SLAF
C/O Suffolk Highways

Date: 30 September 2020

Representation to the Planning Inspectorate by the Suffolk Local Access Forum in response to the Development Consent Order by NNB Generation Company (SZC) for the proposed Sizewell C Nuclear Power Station. Planning Inspectorate Reference: EN010012

DRAWING TITLE:
 CONSTRUCTION PHASE

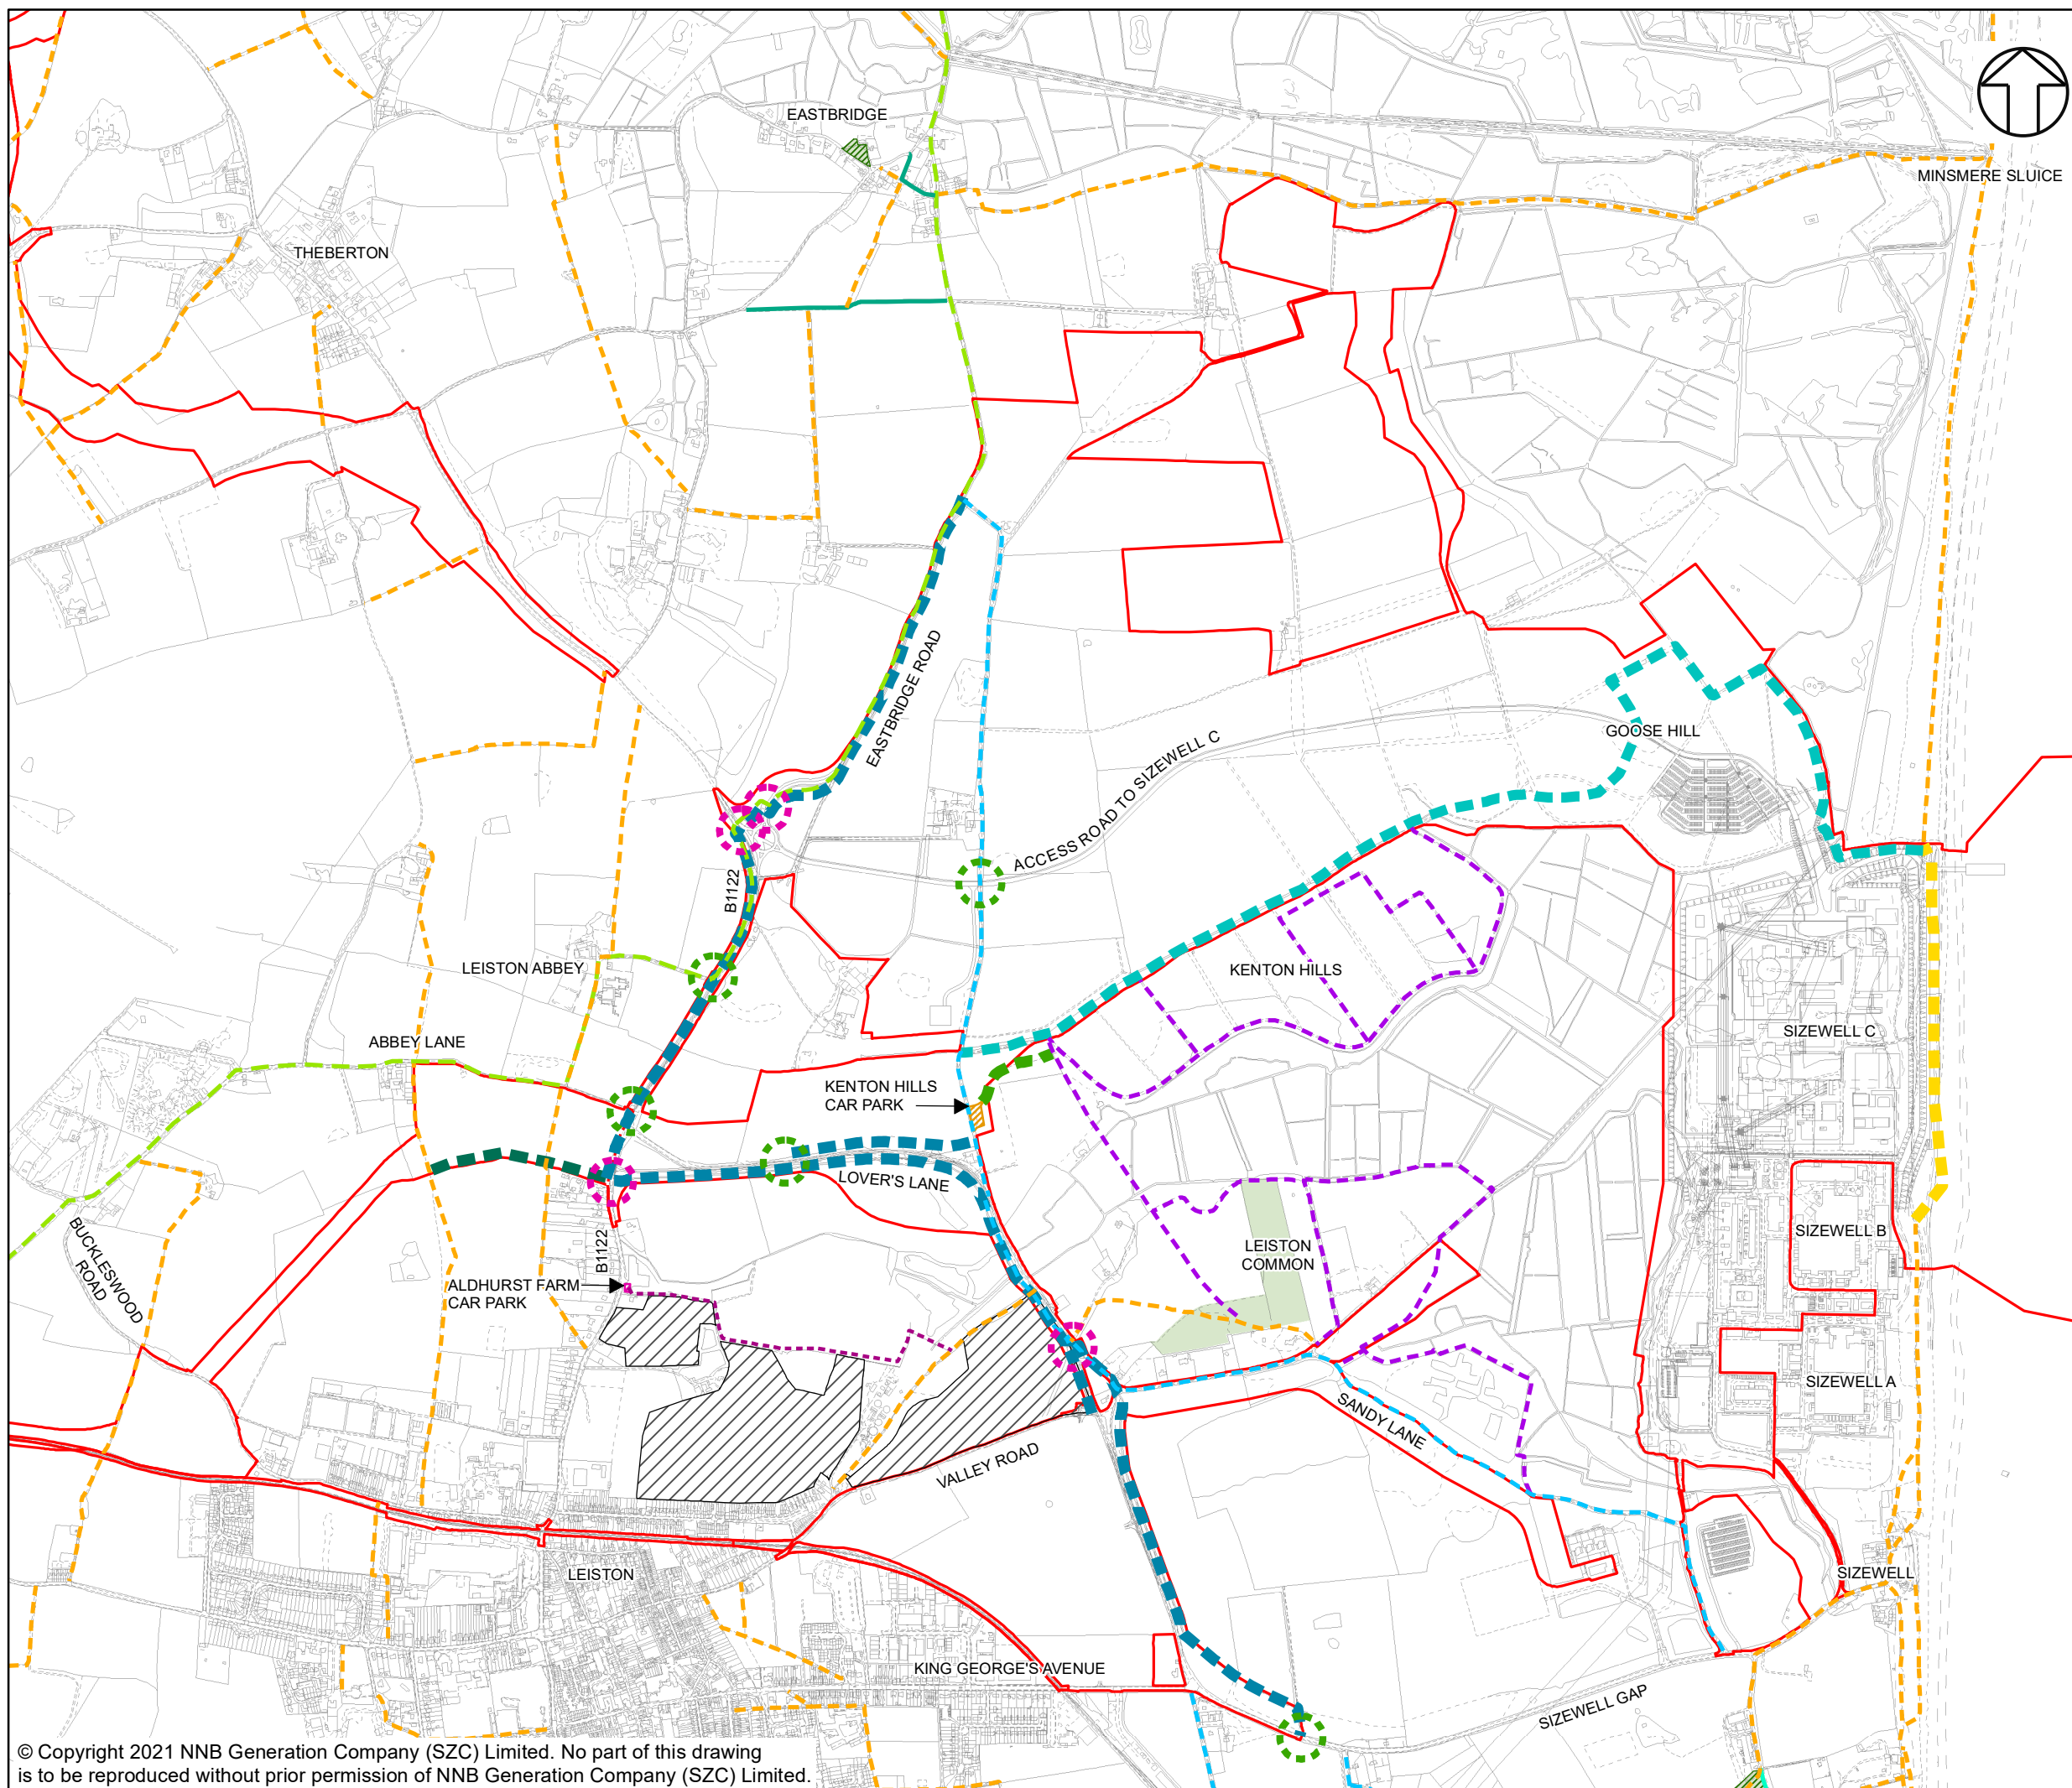
With regard to the local rights of way network SLAF has accepted the loss of Bridleway 19 during the construction period and welcomed the provision of an off-road route adjacent to the Eastbridge Road but would ask that this route is continued to Eastbridge itself. We would also ask for a safe pedestrian link from the B1122 through Aldhurst Farm to meet with Sandy Lane.

As you are well aware, the role of SLAF is to advise the local highway authority and other organisations on access issues and that has been our focus during each stage of consultation. We welcome the amendments proposed to the proposed Bridleway19 diversion which will be used during the construction phase, particularly the reduction in road crossing points, the split surface shared route for equestrians, pedestrians and cyclists, also the new link to the proposed worker's caravan site. However, we would like to see the off-road bridleway route to be extended further north towards Eastbridge itself before it meets Eastbridge Road. The safe crossing points to be constructed as part of the Bridleway19 should be retained post construction.

DRAWING TITLE:
 OPERATIONAL PHASE

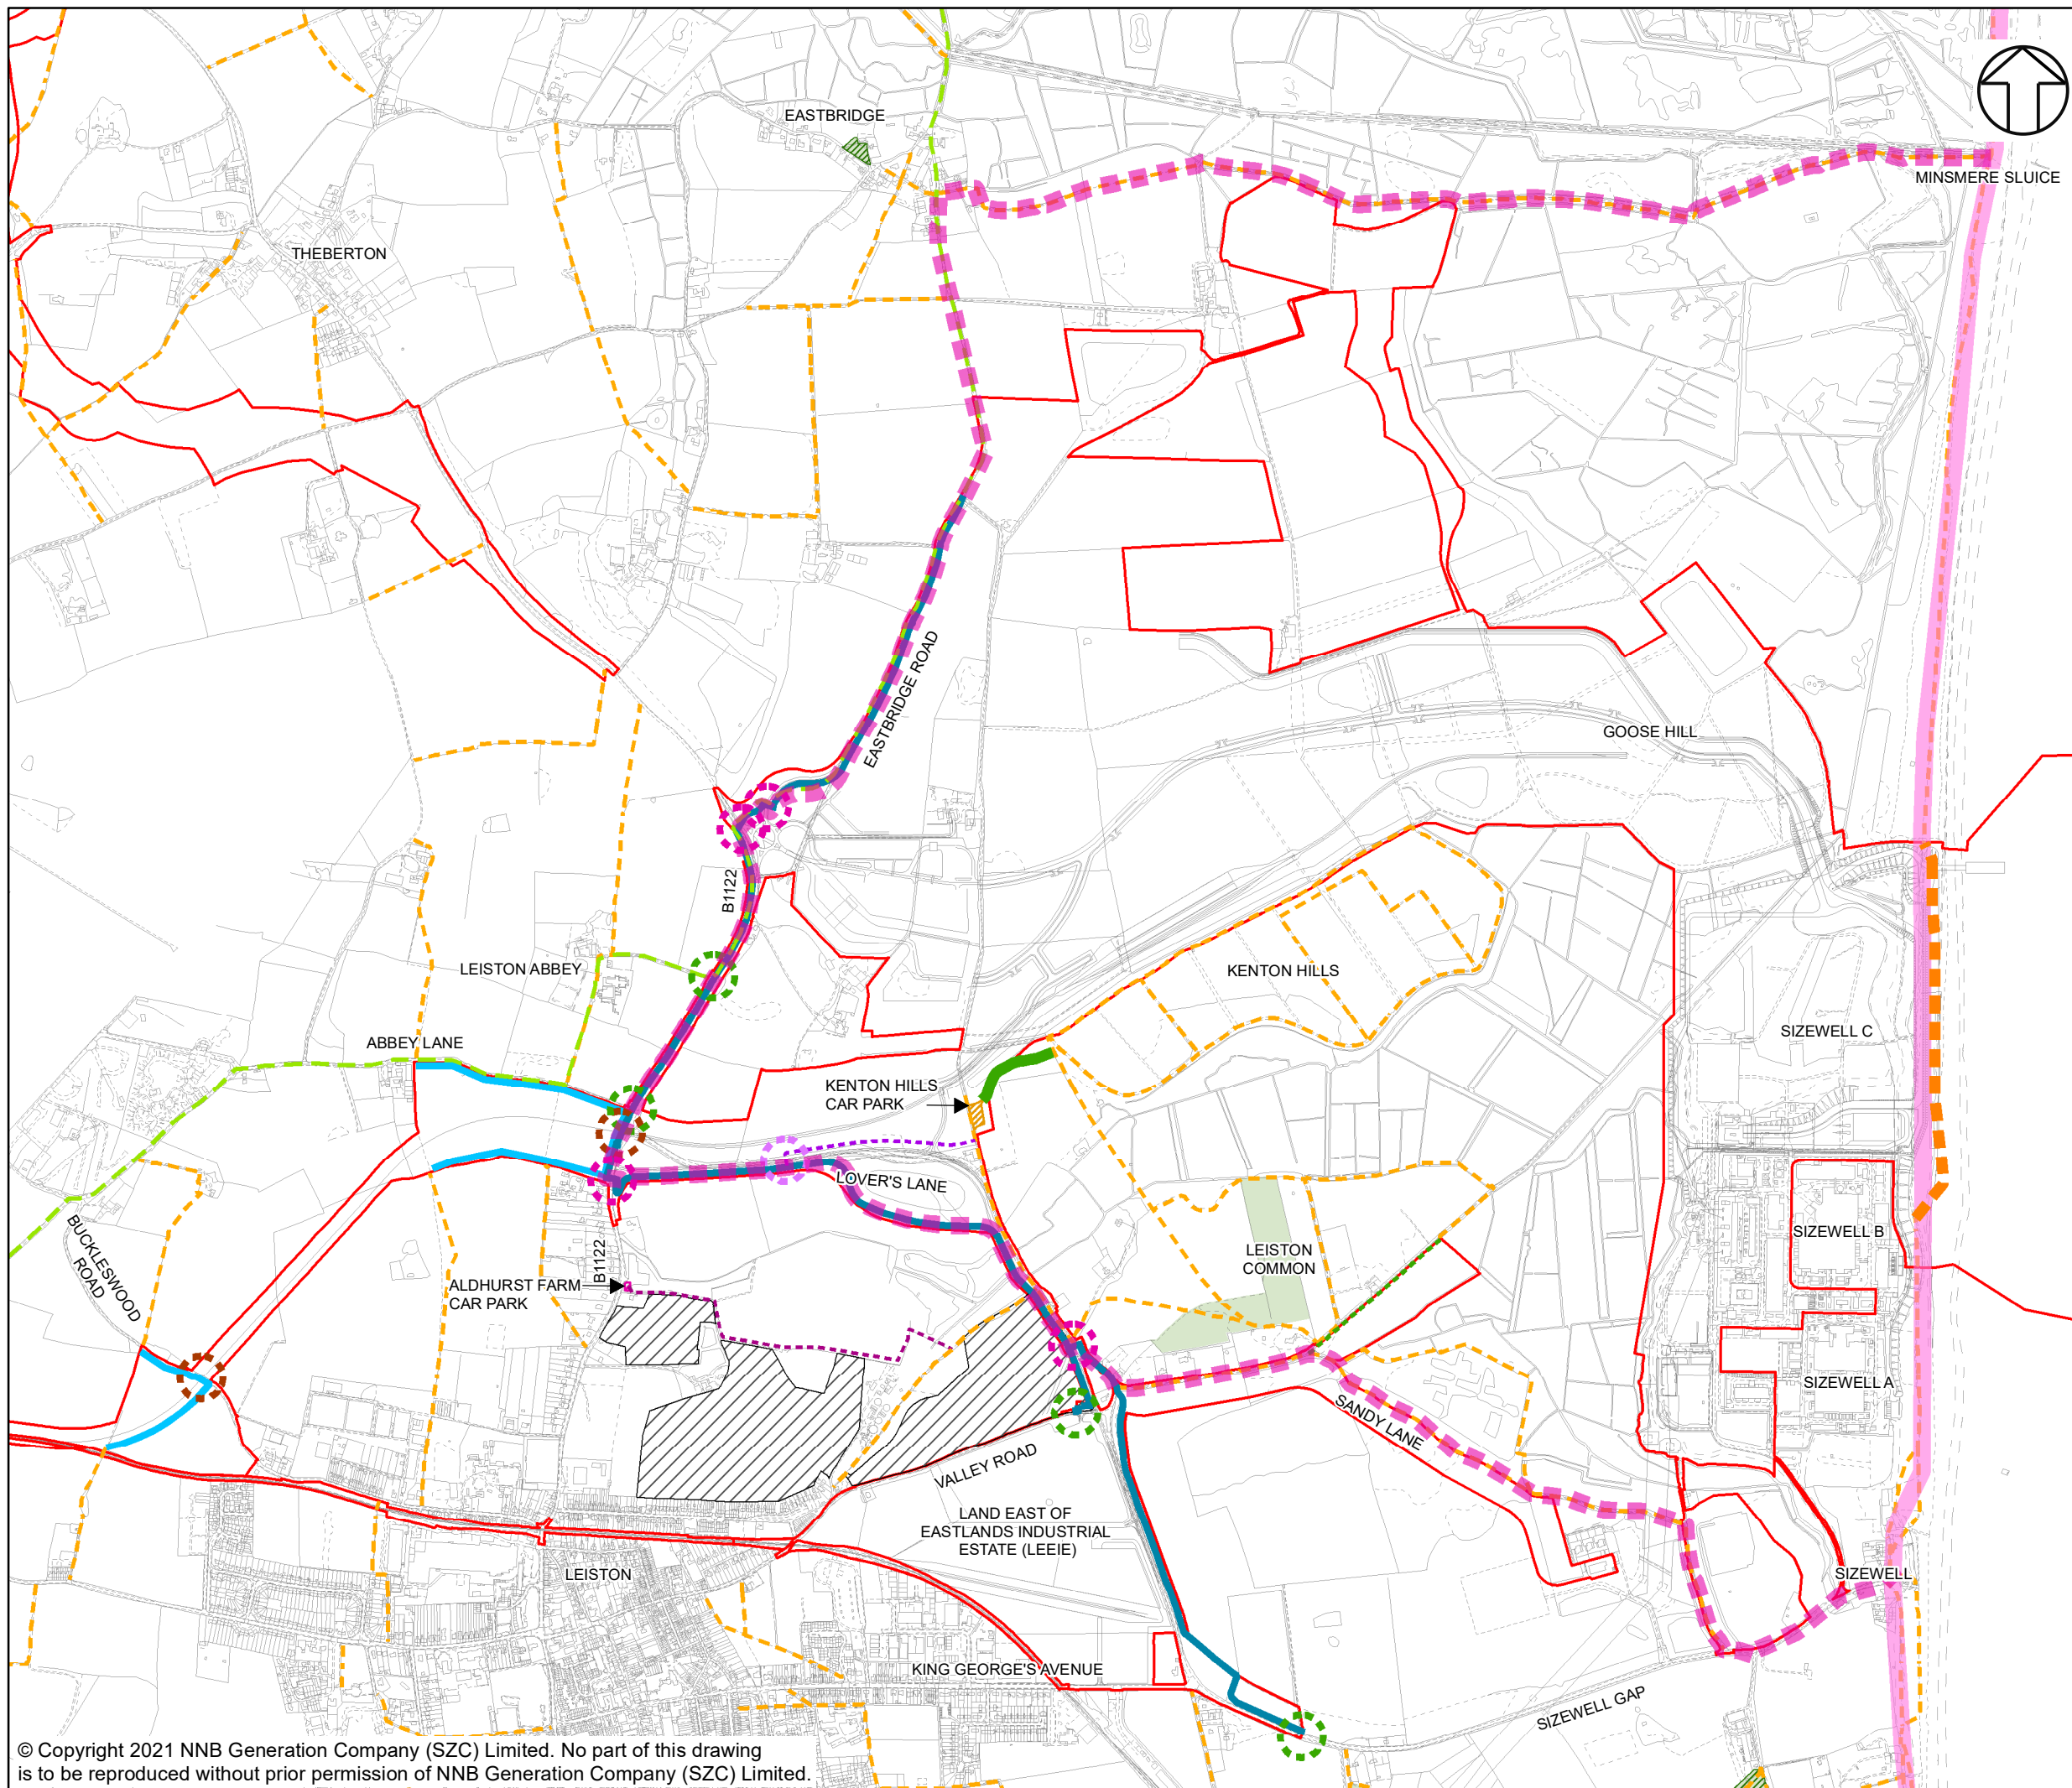
Post construction, SLAF are requesting that there should be a significant legacy benefit to the public access to the wider area around the power station including the permissive routes around Kenton Hills becoming definitive, with a new link to the coast path and better off-road cycle routes between Aldeburgh and Southwold.

At Kenton Hills, whilst we welcome the new connection route to the permissive path network we would like to see post construction the link between Bridleway19 and the Coast Path become a definitive route as part of the legacy.
